OXFORDSHIRE COUNTY COUNCIL'S RESPONSE TO CONSULTATION ON THE FOLLOWING DEVELOPMENT PROPOSAL

Application no: 14/00702/REM

Proposal: Approval of reserved matters pursuant to Outline permission 05/01337/OUT - Proposed spine road.

Location: Land North East Of Oxford Road West Of Oxford Canal And East Of Bankside Banbury

Longford Park, Banbury  
Spine Road - Overview

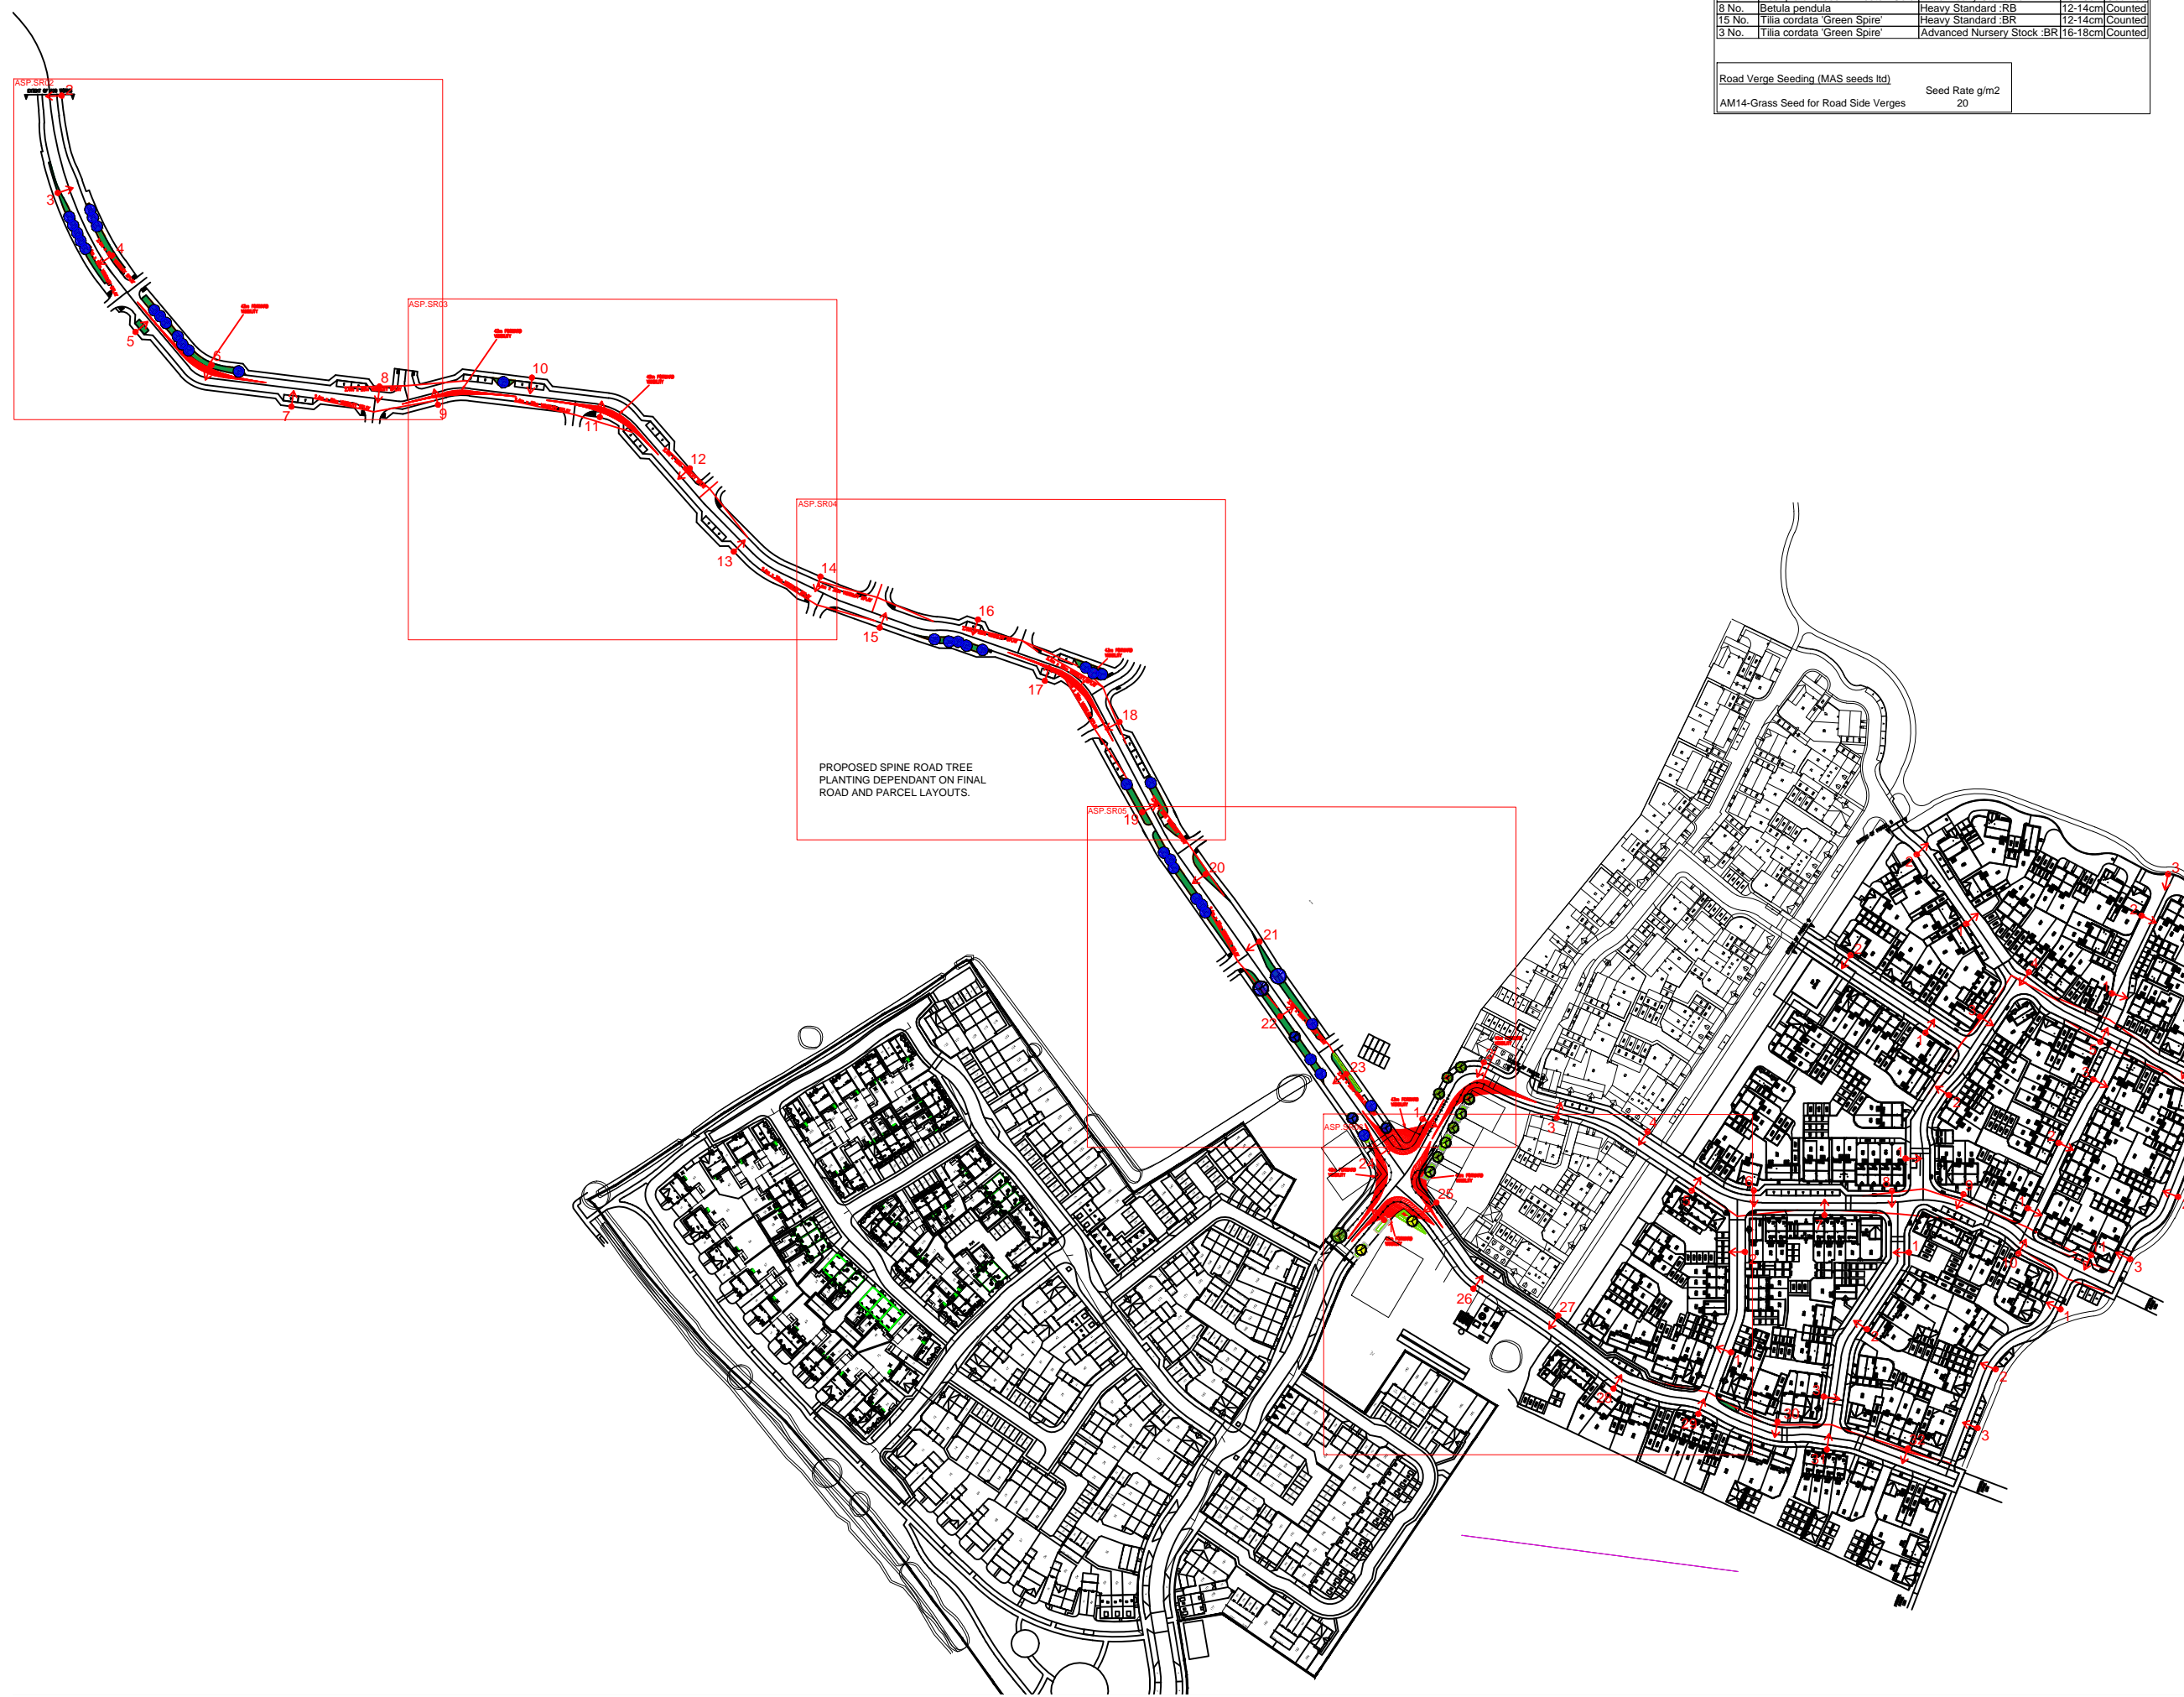
- No tree types shown or specific locations. This is a safety concern as will affect future street lighting design;
- Unclear if spine road is in line with required road width (6m with localised variation and 2m footways on each side);
